DECISION DELEGATED TO HEAD OF PLANNING

Application No: H17-0619-24 **Applicant:** Mr D Vernall
Proposal: Proposed vehicle crossing
Location: 1 Newlands Road Surfleet Spalding
Terminal Date: 12th September 2024

1 Newlands Road - Site Plan

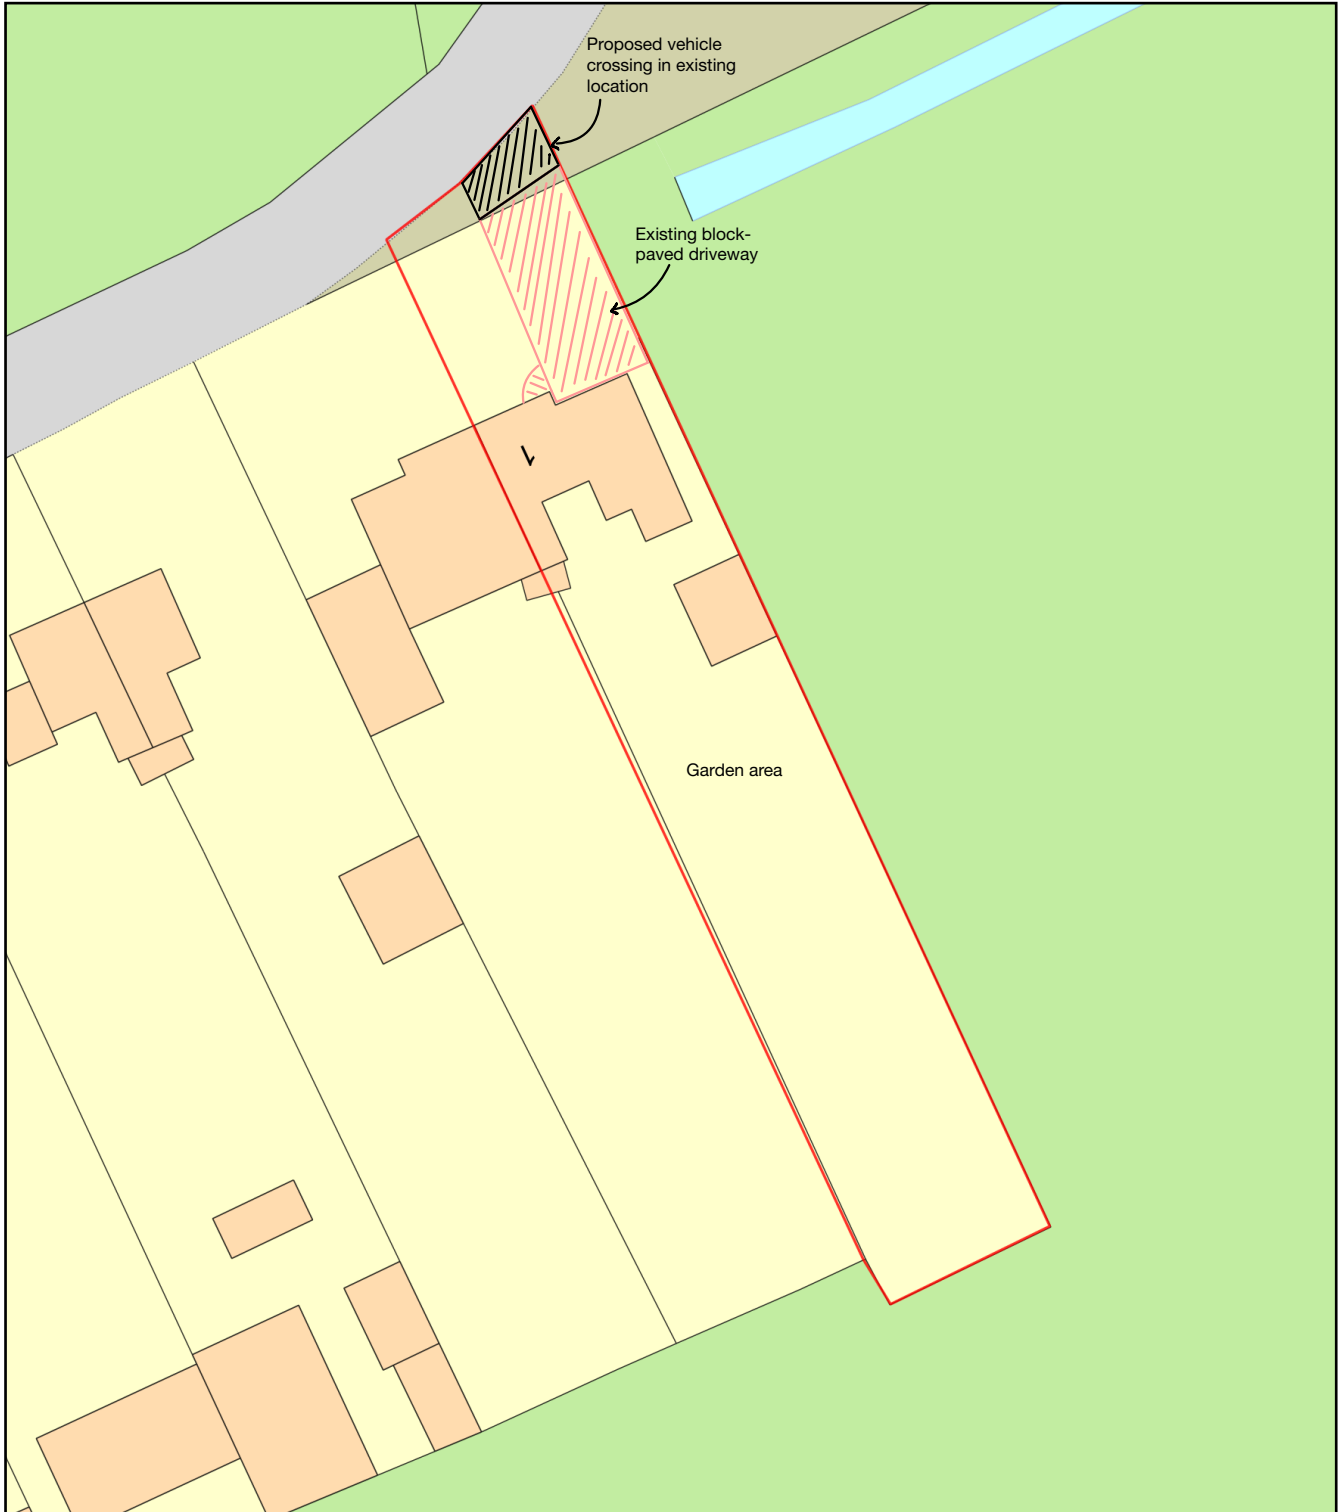
Moreover, from the submitted details, there is reasonable doubt if the site is wholly within the residential curtilage of 1 Newland Road. A portion of the area to be improved appears to be outside of the residential curtilage, potentially within land owned by the Local Highway Authority. As such, the proposed works could not be conducted under Class F, Part 1 of Schedule 2 of the General Permitted Development Order.
